KITTITAS COUNTY

MEMORANDUM

TO: All Staff
FROM: Public Works Plan Review Team
DATE: September 14th, 2022
SUBJECT: SX-22-00017 Klaus

**RECORD OF SURVEY**  
**LOTS 54 AND 55, BLOCK 4, ELK MEADOWS**  
 WITHIN THE SE1/4 OF THE SE1/4 OF SECTION 22, TOWNSHIP 20 NORTH, RANGE 14 EAST, W.M., KITTITAS COUNTY, WASHINGTON

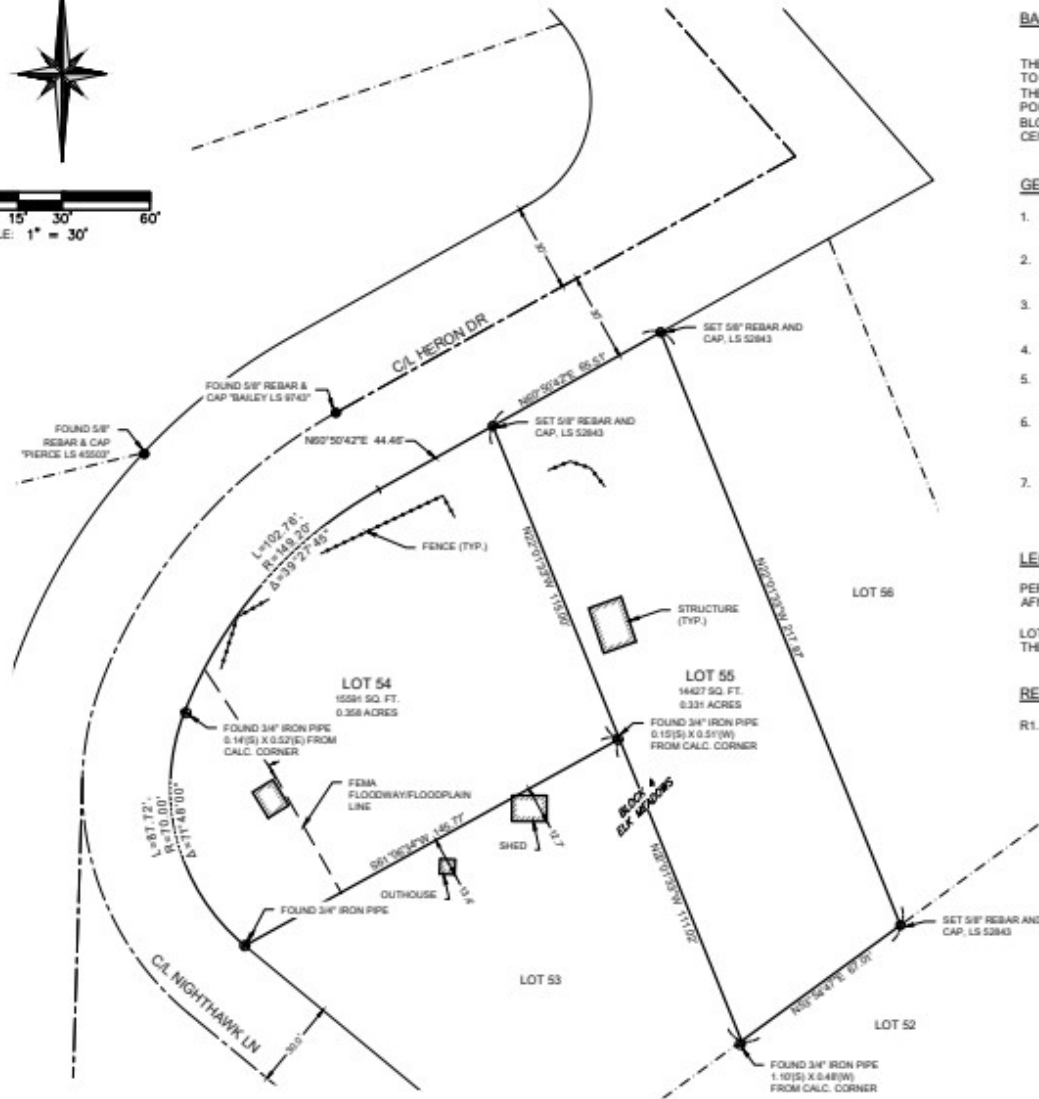
ACCESS	
ENGINEERING	No comments
SURVEY	
FLOOD	The proposed project is within the FEMA-identified special flood hazard area. A floodplain development permit is required, and the project will need to meet the standards identified in KCC 14.08. To ensure that the gazebo does not encroach into the FEMA designated floodway, the floodway boundary will need to be marked on site by a licensed surveyor and the gazebo will need to be located outside the floodway boundary.
WATER MITIGATION/METERING
